From: [Holly Erdman](#)
To: [Dusty Pilkington](#)
Subject: RE: BL-18-00006 Garrison
Date: Monday, May 21, 2018 4:08:51 PM

Please review this Boundary Line Adjustment (BLA) application, BL-18-00006 Garrison, and submit comments for the decision. Control Click on the hyperlinks below. Comment period for this application ends on **05/31/2018**.

# BLA EXHIBIT

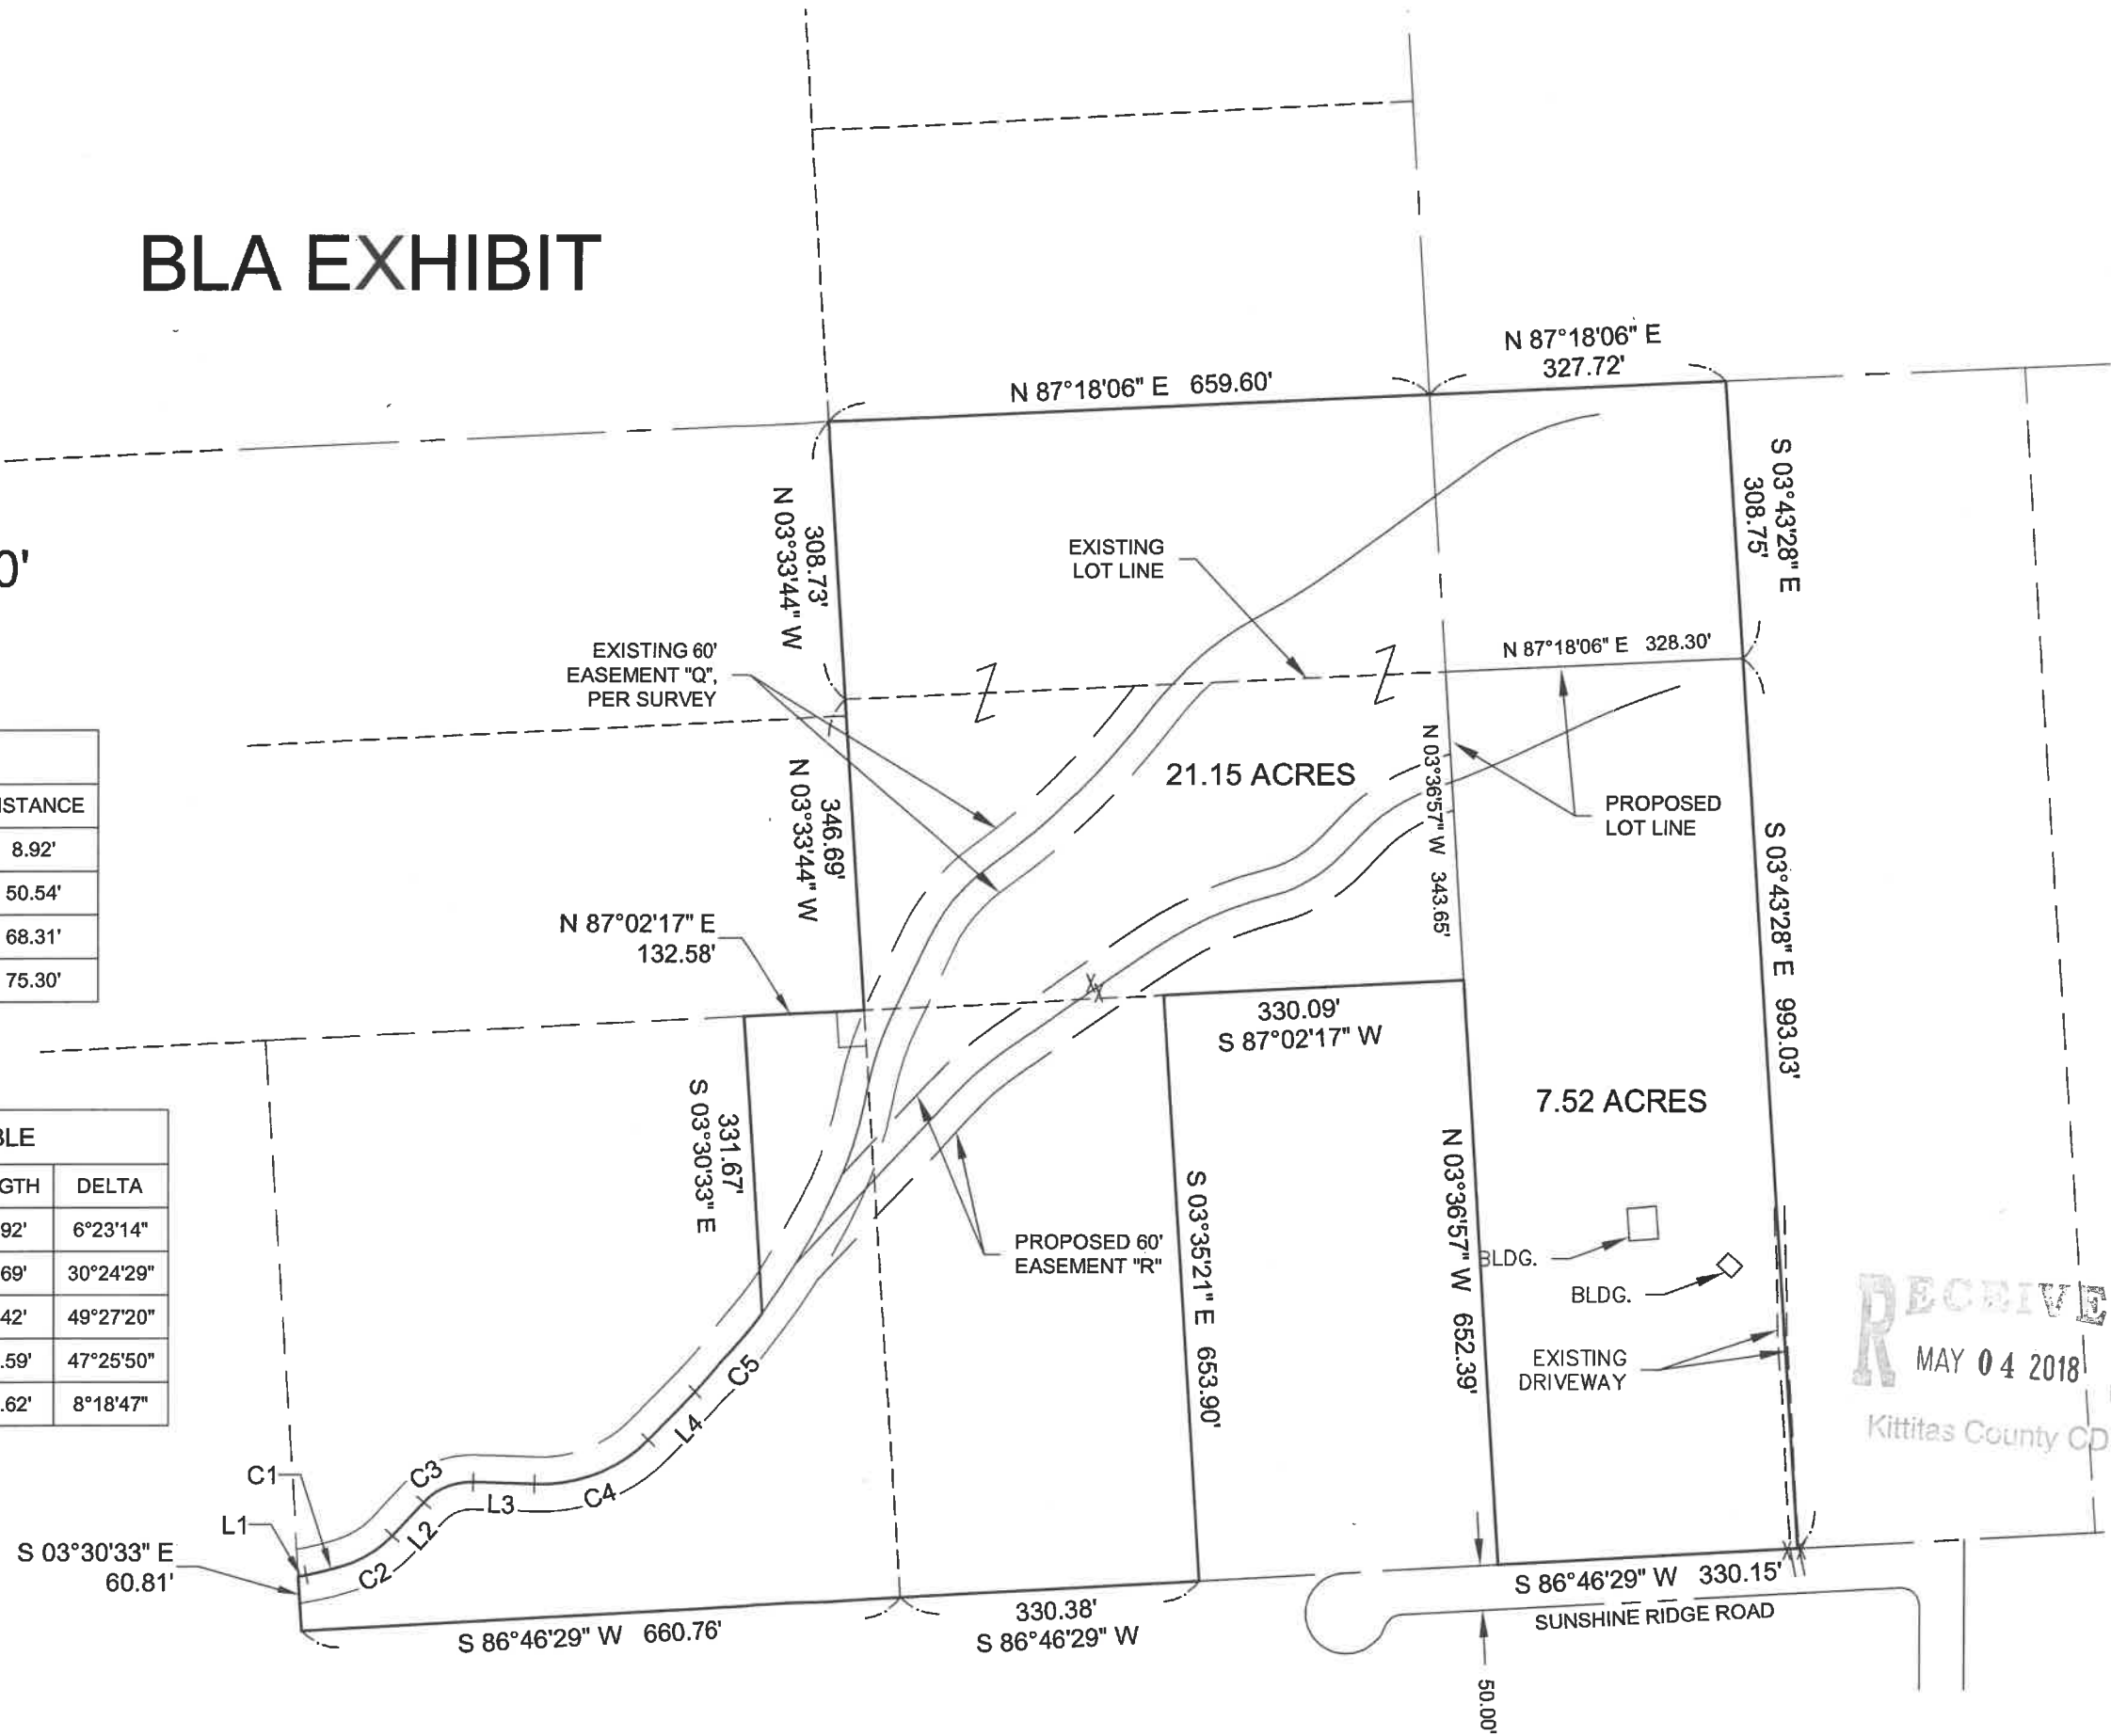
When I look at page 12, I don't see the 1 acre piece identified. The new acreage of one piece is shown and the existing acreage of another piece is shown. Is there a different drawing available?

In the project narrative of this boundary line adjustment application it is stated, "Sewage is disposed of via existing septic tanks and drainfields." Buildings are shown on the site plan but no existing septic systems are shown. Are there any that should be? Are there any existing wells that should be shown?

OK. Thank you. We need the septic system located on the drawing or on a site plan. Our public health records and as-builts often don't show the entire site plan very well, making it difficult to determine the complete layout of everything. It is best if we just have system located on the drawing the applicant submits.

This response from the applicant is insufficient. I need an adequate site plan showing the location of the drainfield and septic tank. The applicant states, "The tank is about 50 feet west and south of my building," but which of the two buildings is he referring to? He also states that "T" posts mark the ends of the drainfield lines. Does this mean we are supposed to make a field visit to gain information that should have been provided?

Additionally, in the project narrative under water source it says "unknown". Knowing that the lot was served by the Sky Meadows water system would have been helpful information to have during the original review of the project.

There is no well. We are on Sky Meadows water system. The septic system was constructed with a county permit and there should be a plan on file. Our project engineer is out until next week. The septic tank is about 50 feet west and south of my building. The ends of the drain field are marked with steel T-posts.
